Application no: H09-0385-10

Description: Erection of pair of flats

Location: Rear of 56 High Street
Holbeach
Spalding

Amendment: Revised boundary treatment (Dwg no. KL/10652/01C)

SITE PLAN
SCALE 1:200

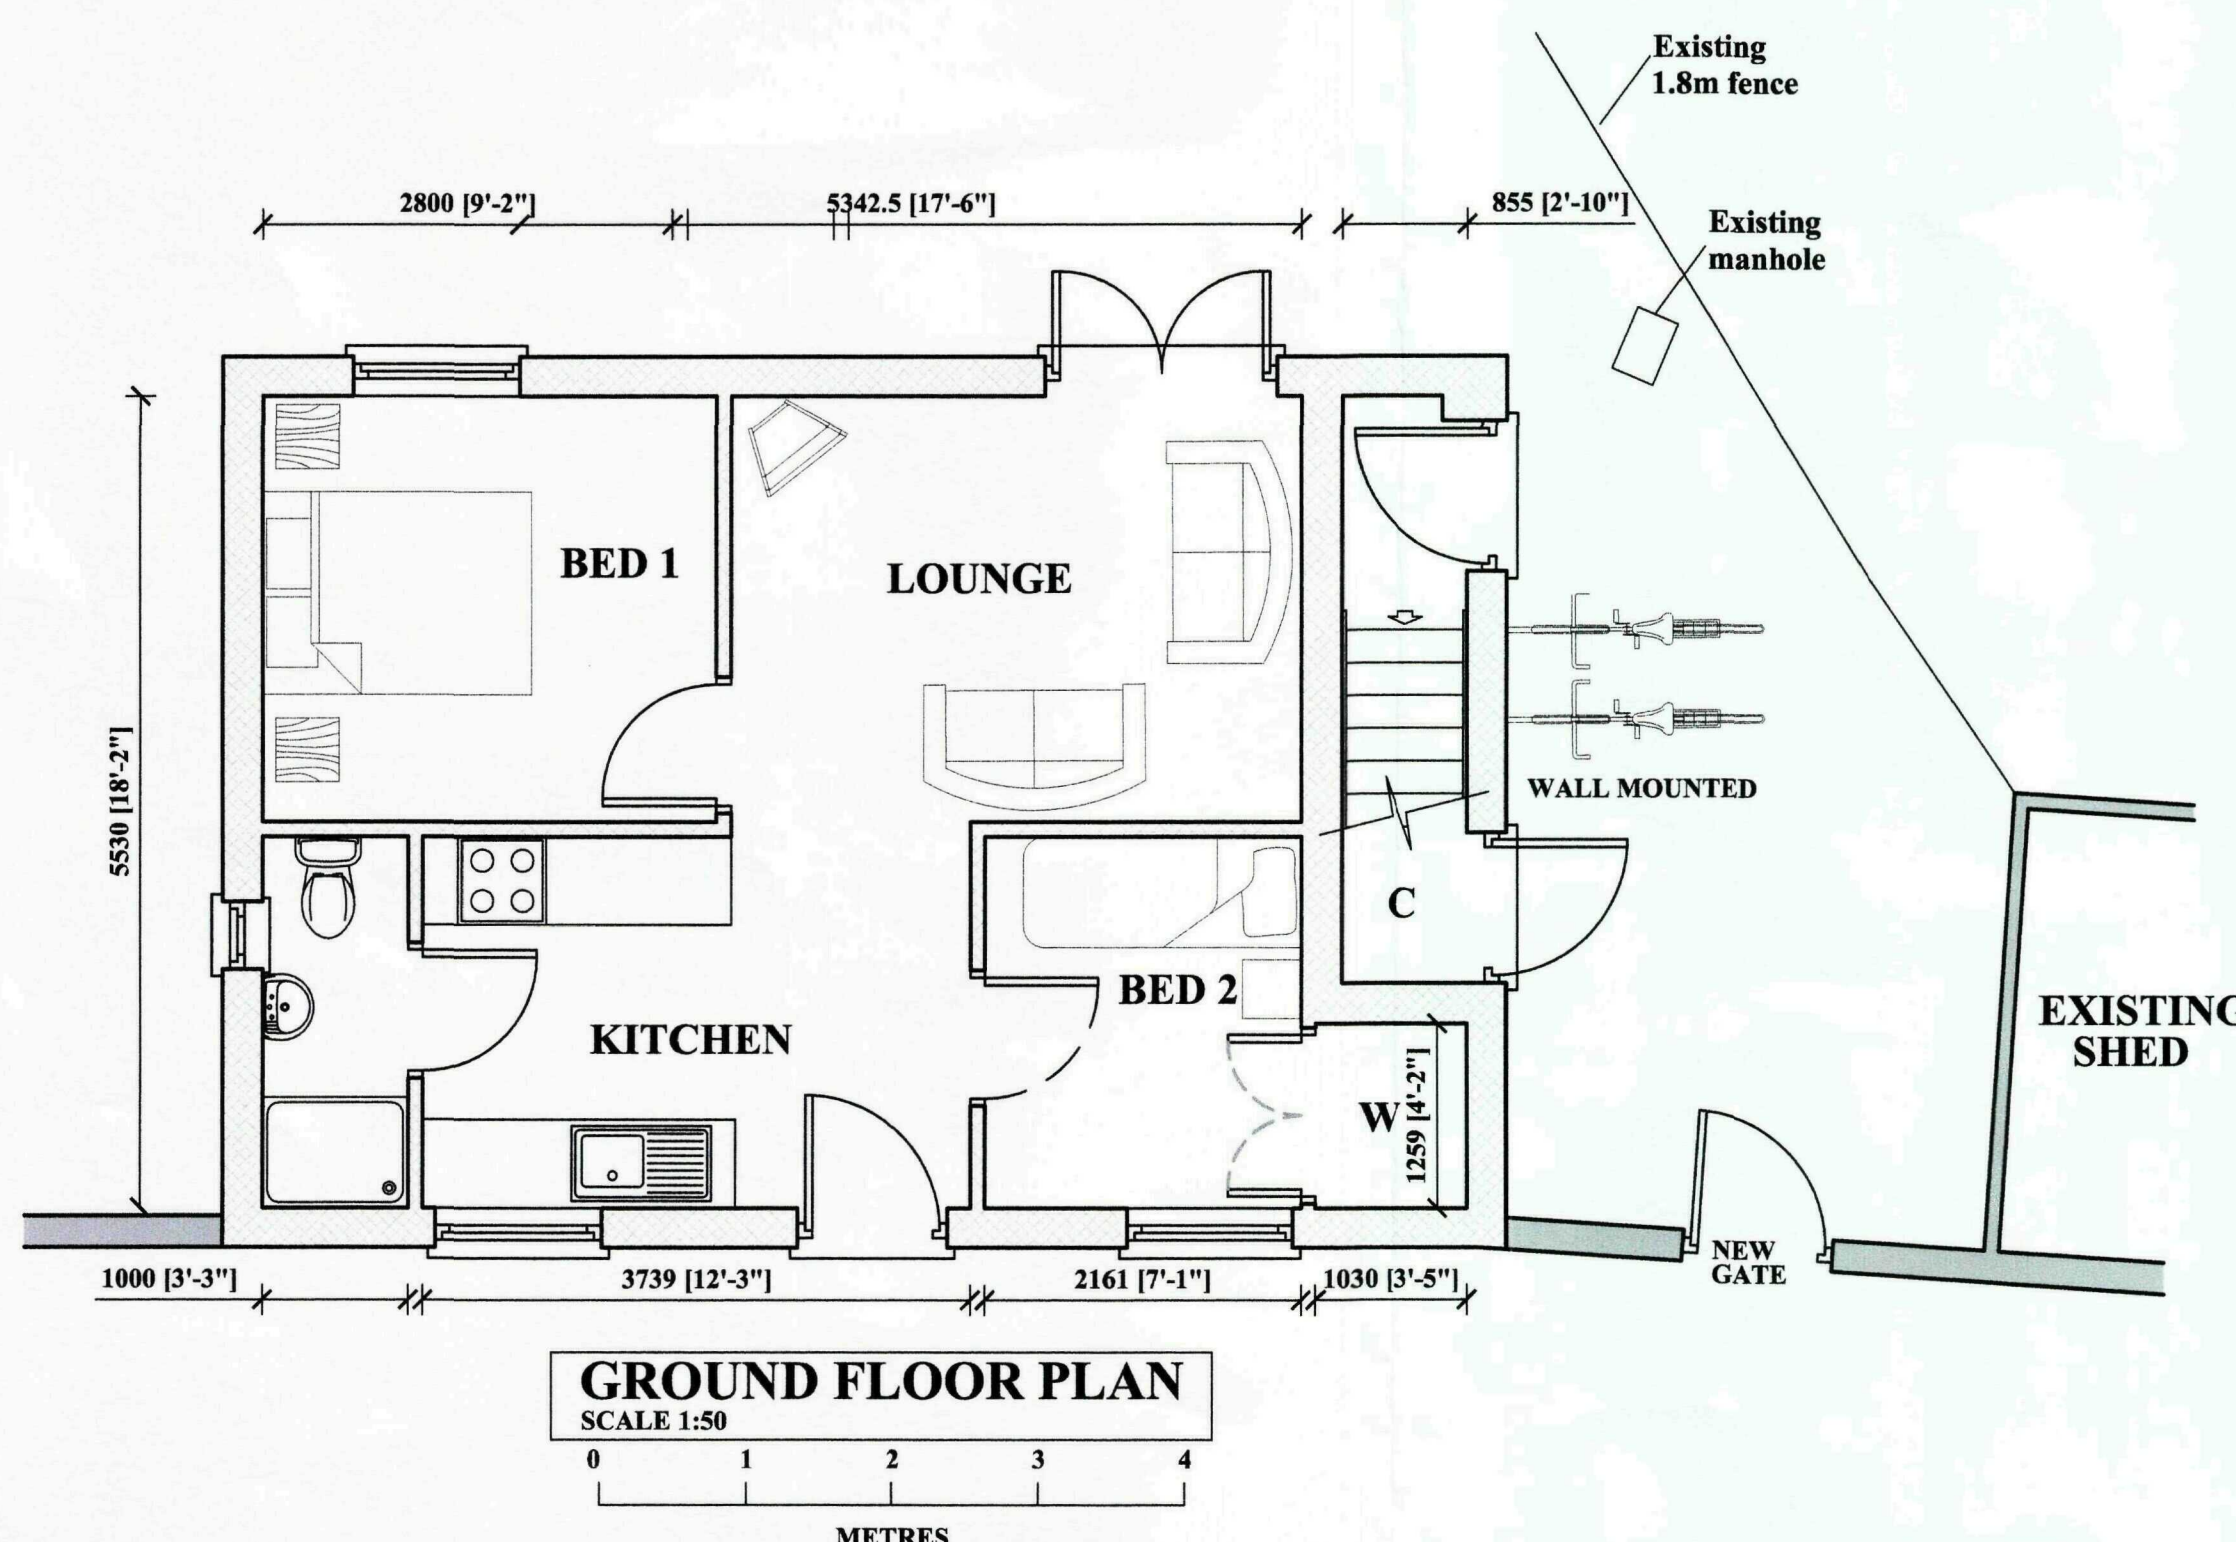
We still need clarification in respect of boundary treatment along the rear and side boundaries, to protect the amenity of nearby residents. Can you please indicate on the drawings where and how the boundaries would be screened and whether there would be any gates/openings. It is noted that the rear boundaries are presently screened by fencing, which I assume would be retained. The southern boundary is more sensitive because it is open to public view. Walling would therefore be appropriate along this boundary.

As you can see, the boundary to the South West is currently covered in almost impenetrable planting and is part of a right of way that the client has from the access to the neighbouring property.

Due to this access being maintained, we therefore intend to keep the planting to that side however we have shown the existing rear fence to be extended to the planting and thus isolate the site somewhat from the adjacent neighbour.
